**CROWN SYDNEY HOTEL RESORT**

**SSD 6957**

**BARANGAROO DESIGN ADVISORY PANEL**

**FINAL REPORT**

7 Porte Cochere glazed fins

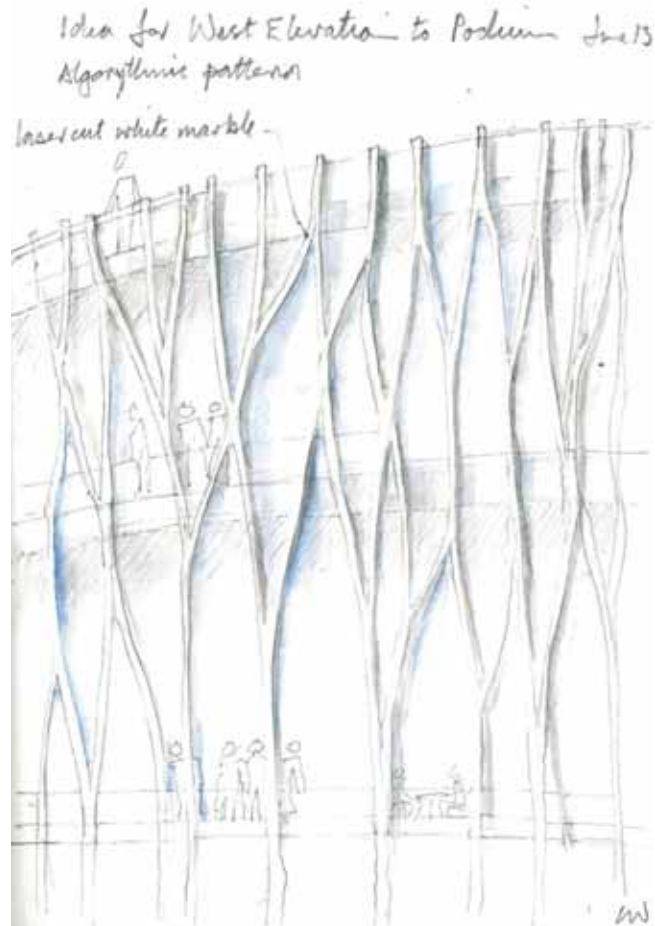
Whilst the glazed fins to the porte cochère are supported by the Panel, particularly the openness to the park to the north, the lack of physical connection between Hickson Park and the Central Parklands demarcated by the podium envelope remains problematic – refer Section 2.1.1 for further detail.

Project:	915.11 Crown Hotel Sydney
Title:	Podium East Elevation Signage
Scale @A1:	1:200
Drawing and CAD File Number:	00915-11-SK-1724
Rev:

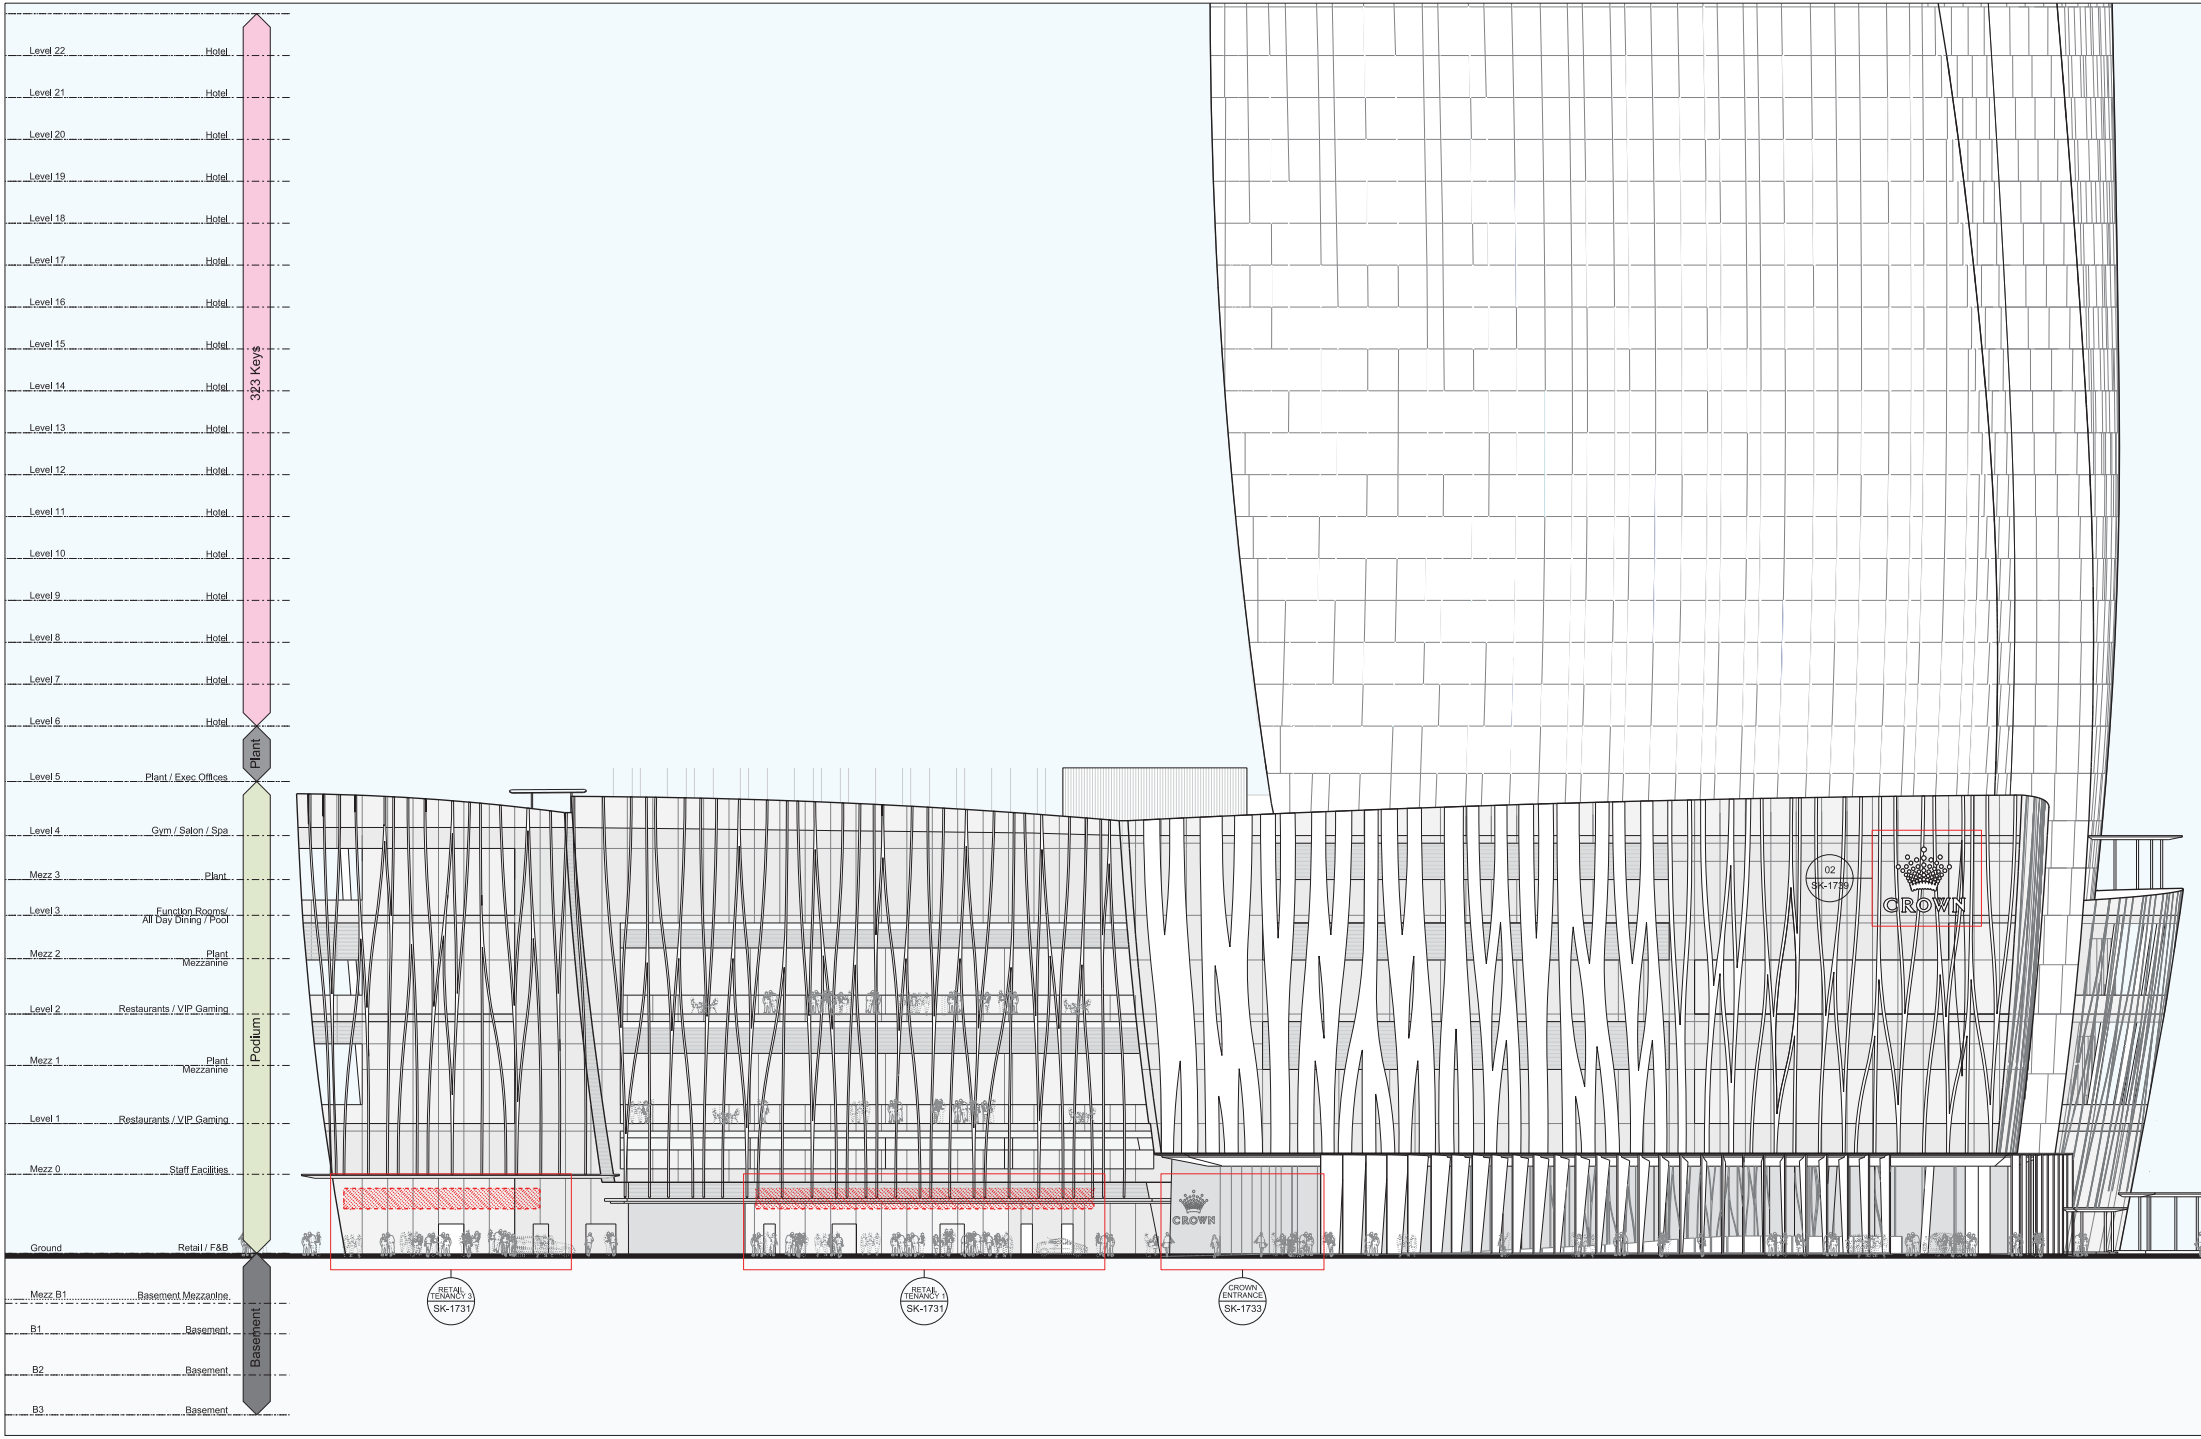
Extensive signage has been proposed for the building as outlined in the Architectural Design Statement. These include Crown logo and text signs of 4.8m x 5.9m to the top of the podium and Crown logo only signs of 6.7m x 5.3m to the top of the upper tower. Montages of the building indicate that the signs will be highly prominent. The Panel re-iterates its view from the MOD 8 BDAP Report that signage to the upper levels of the building (above podium level) is inappropriate and unnecessary as the intended iconic nature of the building will ensure that it acts as its own sign.

- That no branding signage be located on the tower, or at any location on the building above the podium;
